Engineers Comments Regarding Surface Water Drainage

Application Reference:	Y/9/25/DOC	Reviewer Reference:	ADC/PC
Planning Officer:	Amber Willard	Date of Review:	30/06/2025
Site Name:	Fleurie Nursery Lake Lane Barnham PO22 0AL		
Application Description:	Approval of details reserved by condition imposed under reference Y/26/24/PL relating to condition number 4 - surface water drainage scheme, condition number 5 - discharge flows to watercourses, condition number 6 - maintenance and management of the surface water drainage system and condition number 10 - Biodiversity Enhancement Layout.		
Assessment Number:	1 of 2

Application Reference: Y/9/25/DOC Site Name: Fleurie Nursery Lake Lane Barnham PO22 0AL	Initial Issue Date: 21/02/2025 Issue Date: 30/06/2025 Reviewer Reference: ADC/SB & PC
--	---

| C2904   | P      | 201         | P1   |

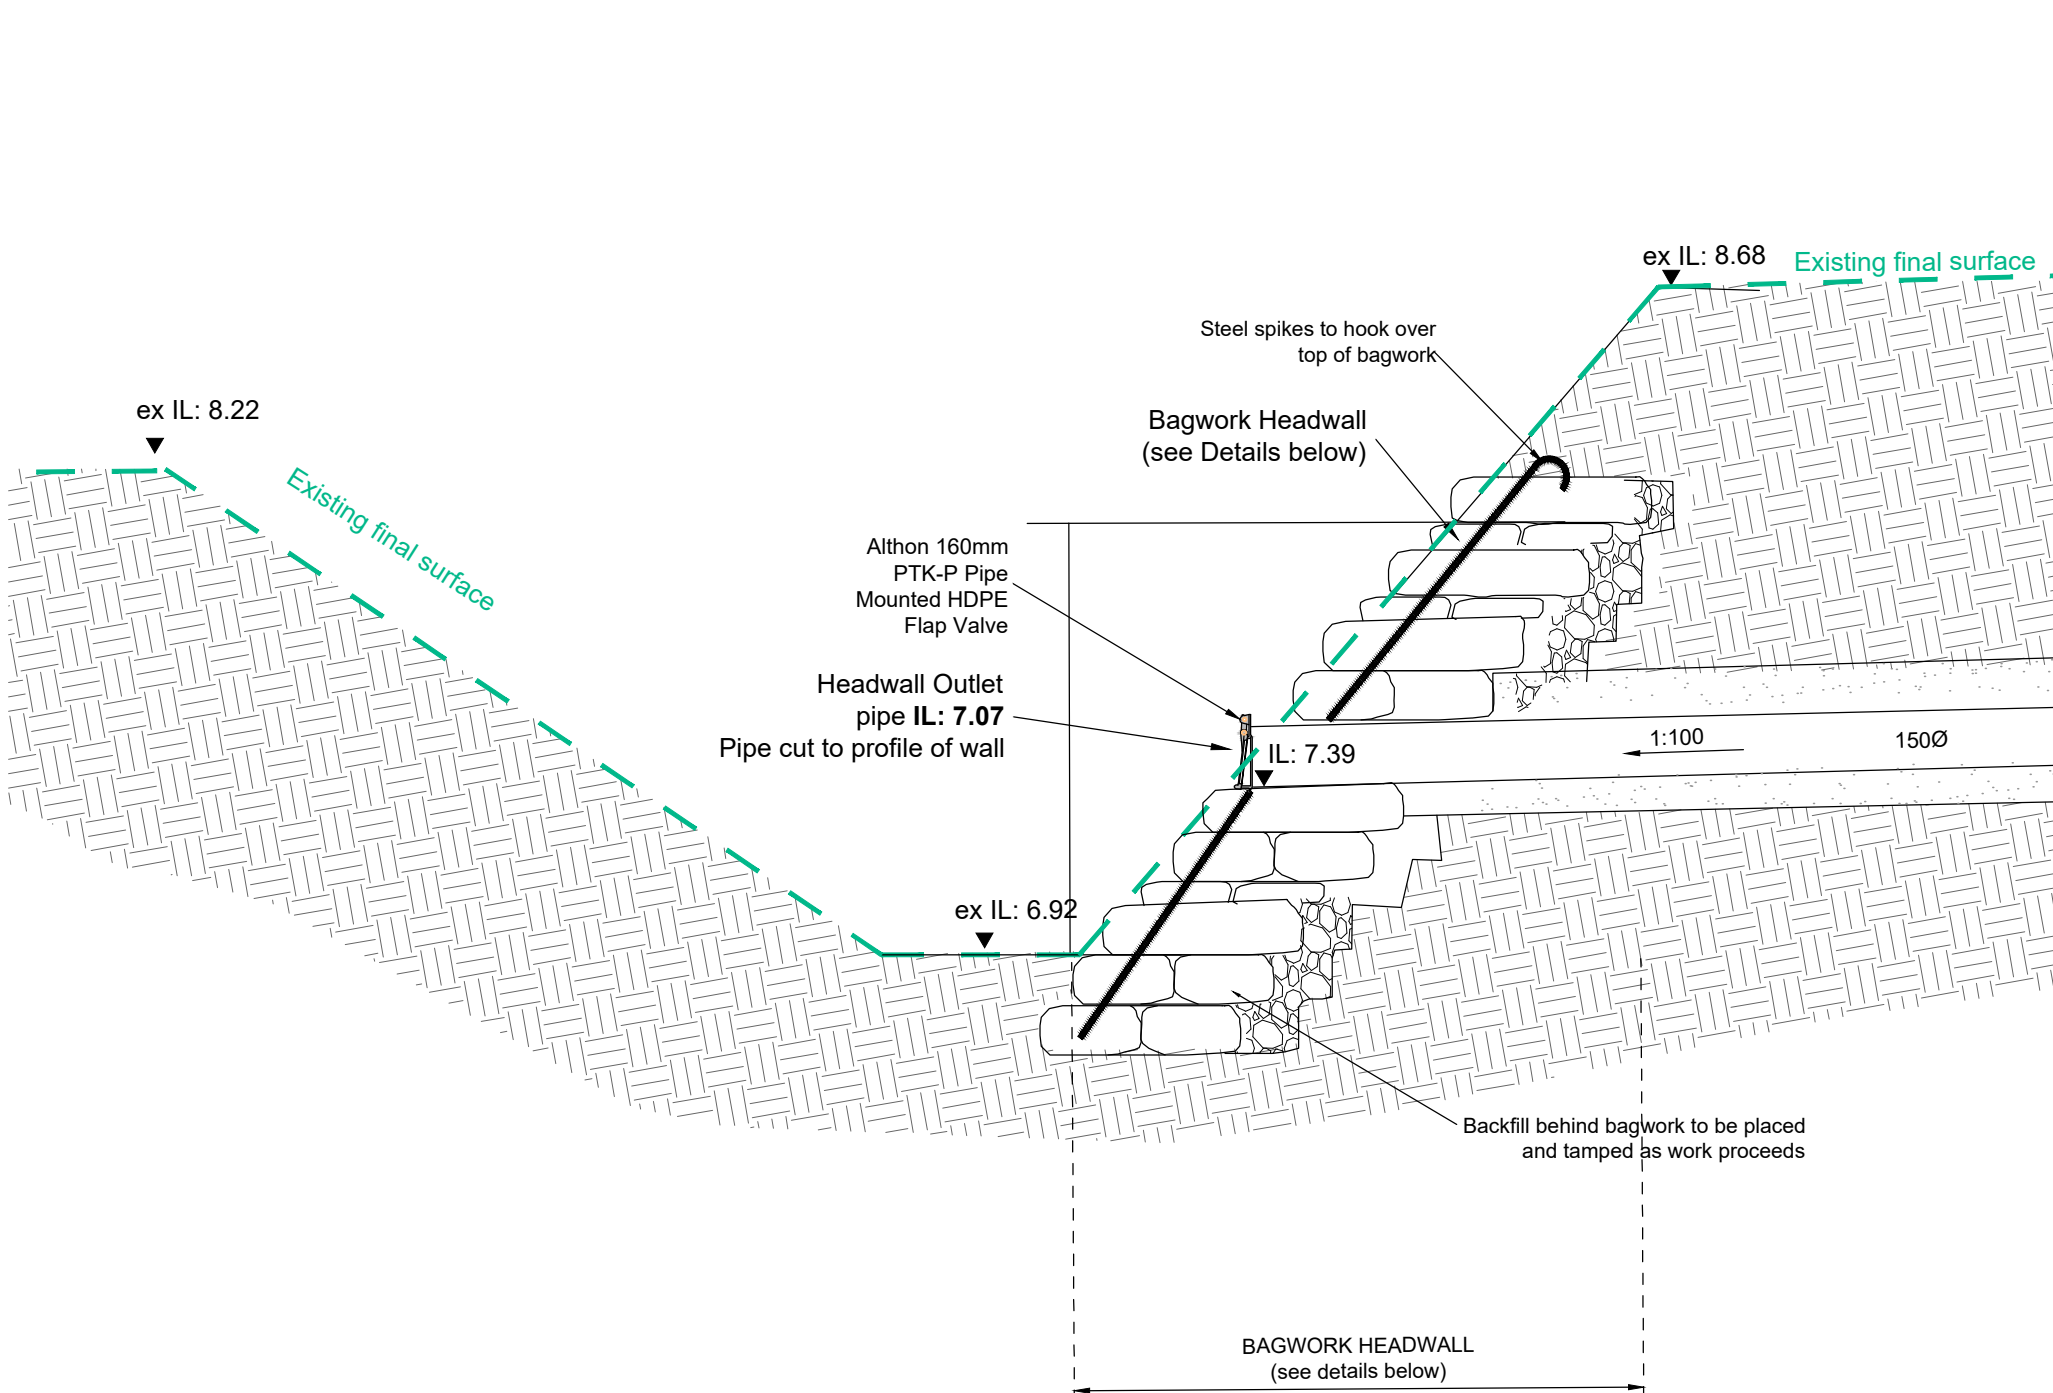
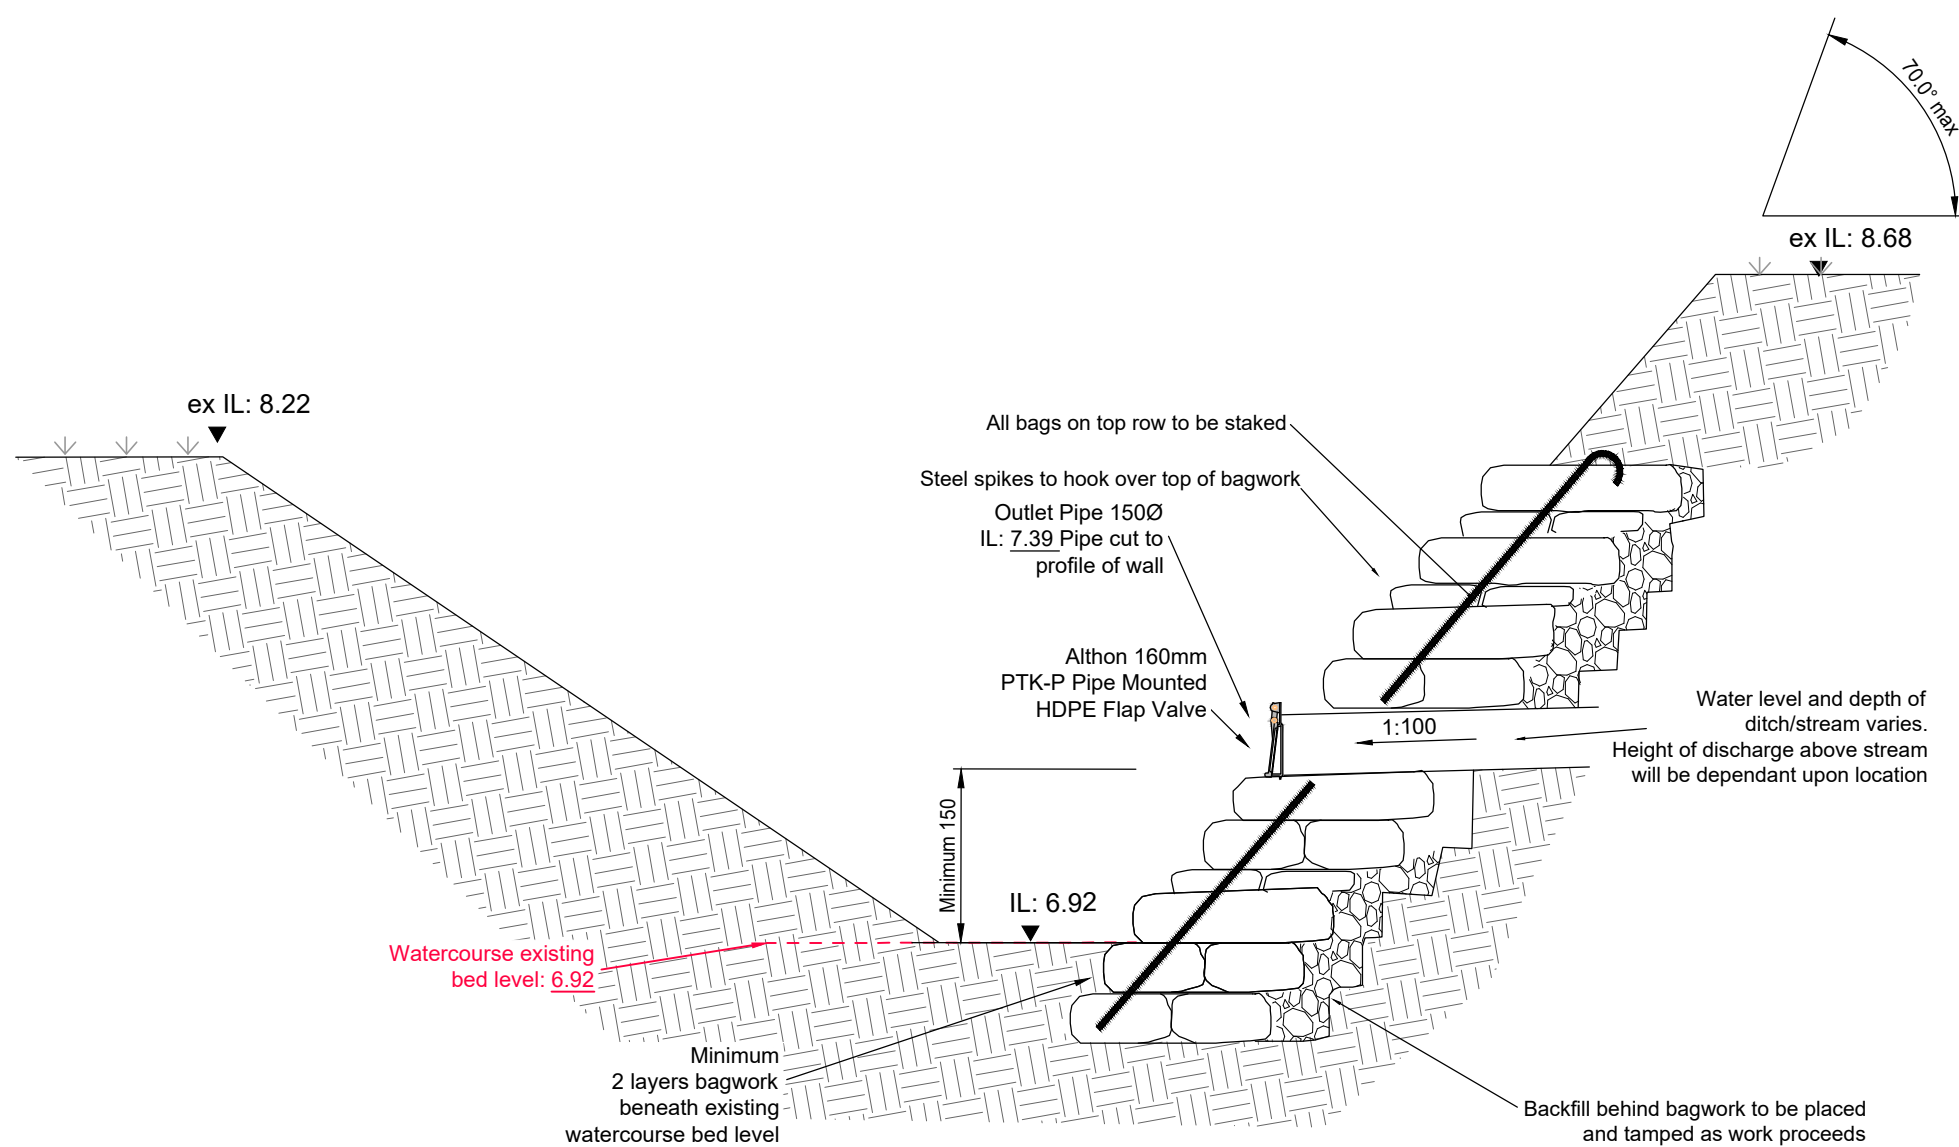
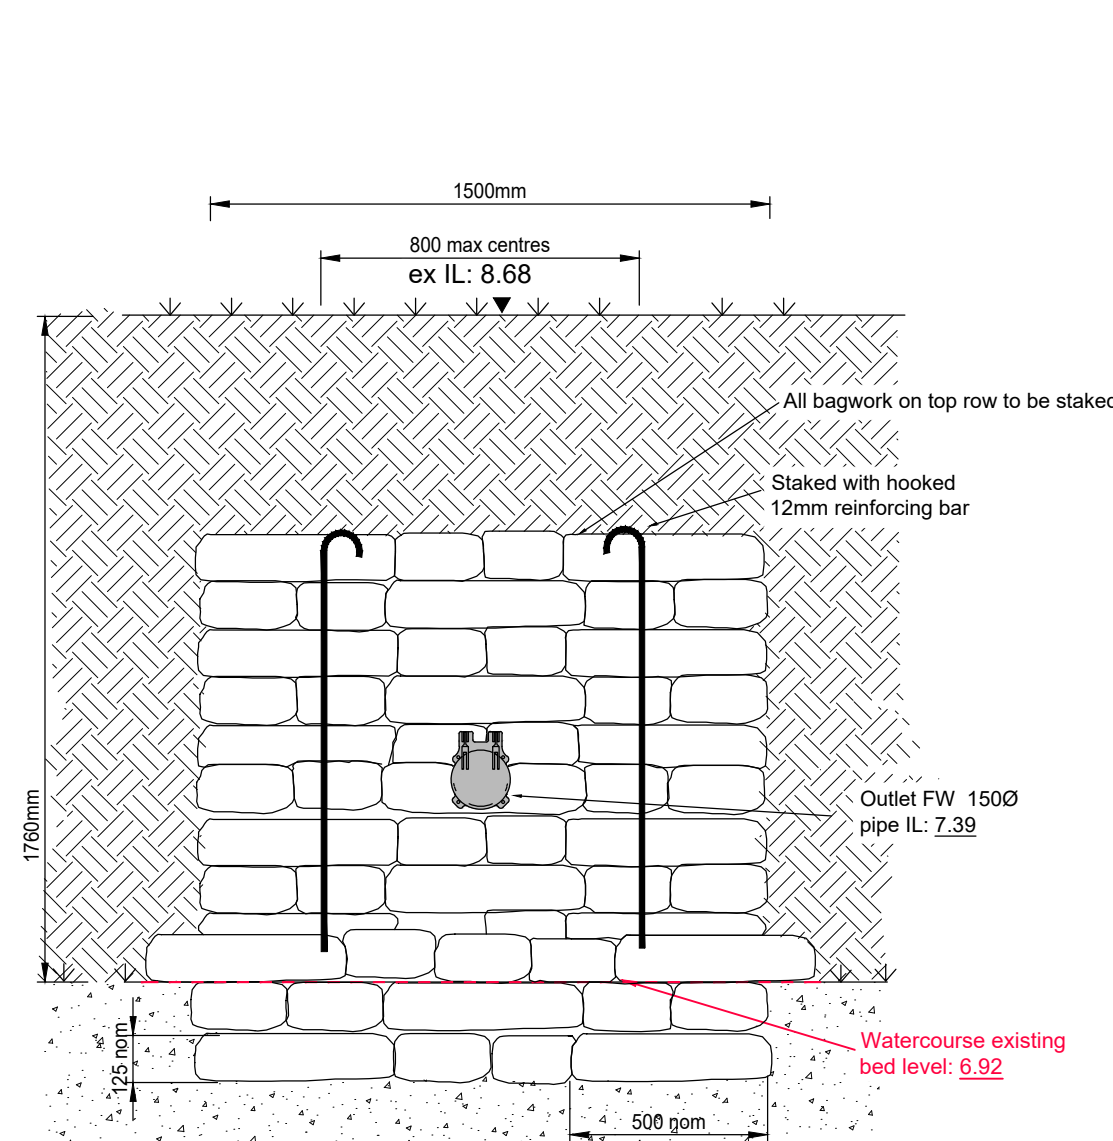
12.	The modelling does not include the flap valve.	Flap Valve is now included	Noted and accepted. Comment closed.		
13.	Please remove the standard (non-site specific) headwall details from C2904-P-501. These contradict the OWC drawings which are more detailed and site specific.	Headwall detail has been removed. It should be noted that OWC drawings have been issued and comments have been received. Drawings are now updated and the updated drawings have been issued for final review.	Noted. Comment closed.

DRAWN	KCK	ENGINEER	TZ	CHECKED	CS	APPROVED	CS
DATE	DECEMBER 2023	SCALE @ A1	1:200				
JOB No.	C2904	STATUS	P	DRAWING No.	101	REV.	P4

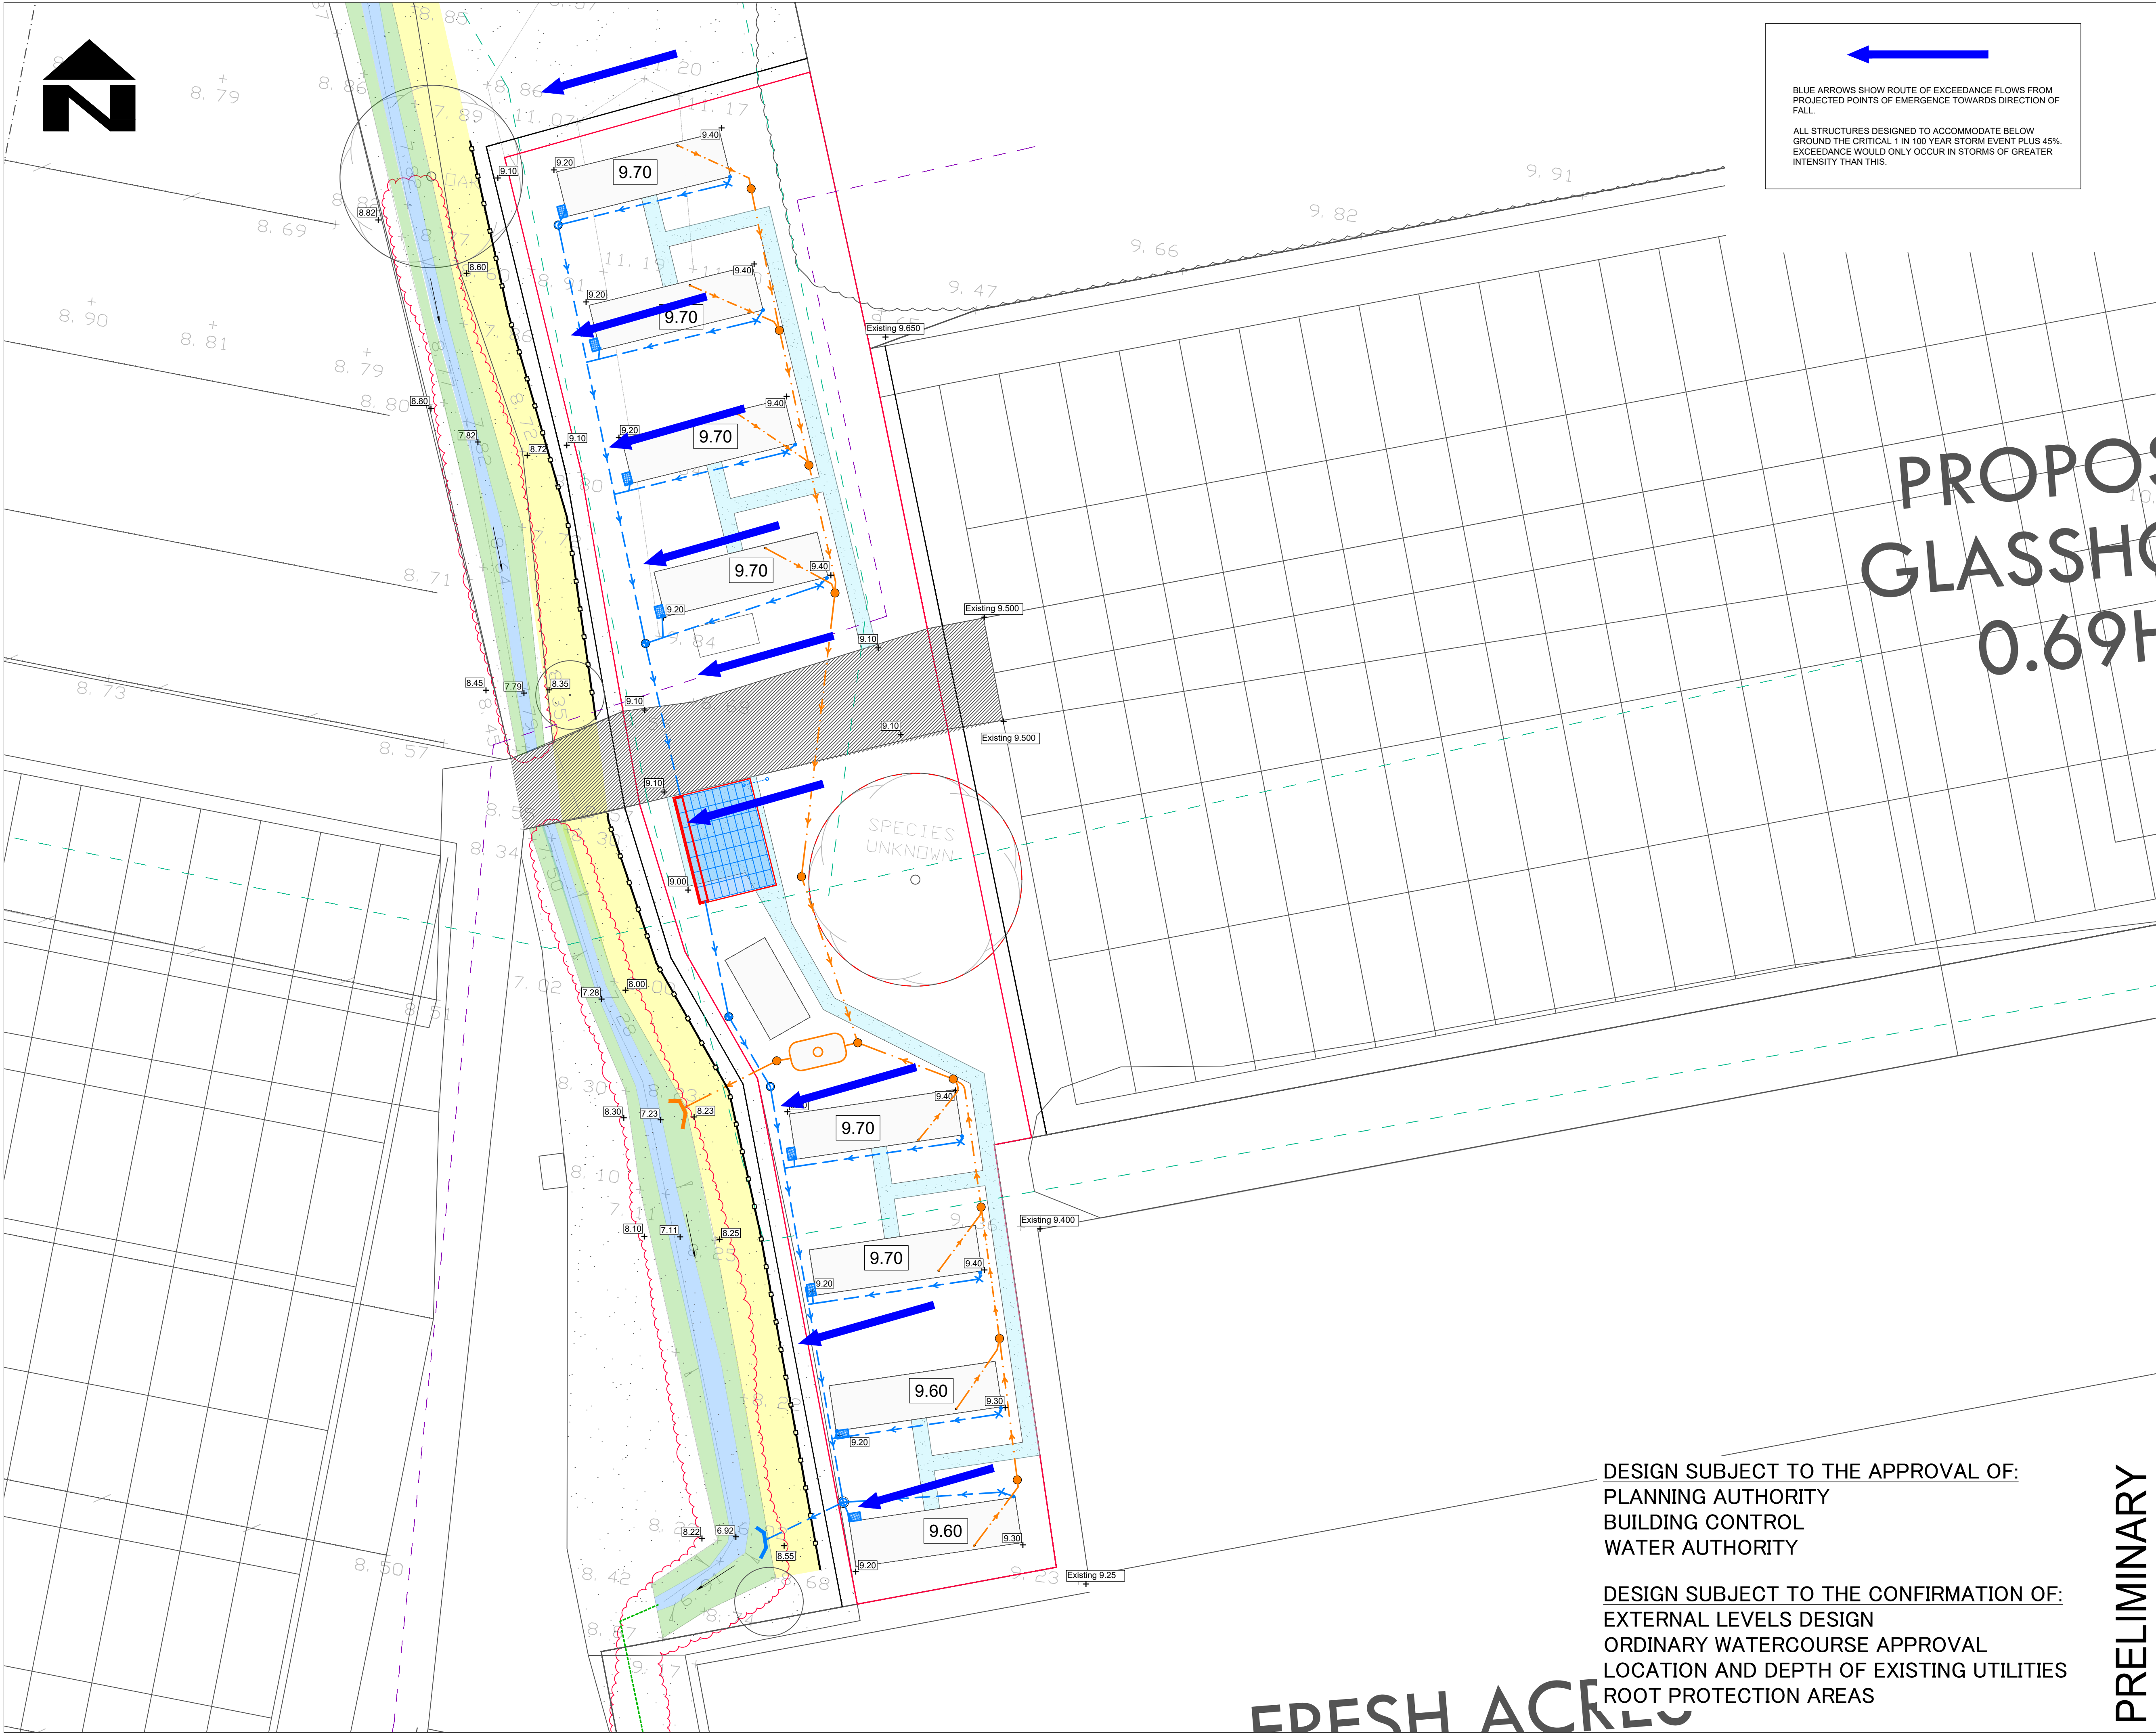
4.	Please correct discrepancies between cover and invert levels on the plans and the calculations. [It is acknowledged that this is unlikely to affect the design.]	Discrepancies are now updated, please find the revised drainage plan and drainage calculations attached.	Cover levels for S3 and S4 differ. Please adjust.

6.	Please show any relevant easements on the plans.	The existing watercourse 3m easement is now indicated on drainage plan	Noted and accepted. Comment closed.

9.	The landscape and ecology management plan refers to a post and rail fence installed post-development to protect the rife. Please clearly demark this fence on the plans and ensure that is not within the easement for the watercourse.	The proposed post and rail fence is now indicated on the proposed drainage plan. Proposed fence is to be located min. 3m away from the top of the banking (easement).	Noted and accepted. Comment closed.

11.	The orifice for S5 is described on the layout as being 500mm diameter. This is assumed to be a typo (confused with the chamber diameter), please correct.	Orifice chamber diameter has been updated to 600mm diameter and orifice diameter to 20mm.	Orifice chamber is shown as 900mm diameter. 20mm orifice noted. Comment closed.

14.	Please detail the overflow level of the Sel Controflow 500 Orifice Chamber.	Overflow level is now indicated on orifice chamber detail.	It is noted that the overflow level of 9.150 is higher than manhole S3 cover level (9.00) upstream, so in the event of a blockage at the orifice, excess water may overflow from S3 before the formal overflow at S5 operates. Please advise.

16.	There is a risk of a clash between the surface water and foul drainage north of S4 and west of F6. Please adjust the design, if possible, to minimise this risk.	Clash has been reviewed and a separate note indicating proposed SW and FW pipes invert levels is now indicated.	Noted. Pipes are close when allowing for pipe thicknesses but achievable. Comment closed.
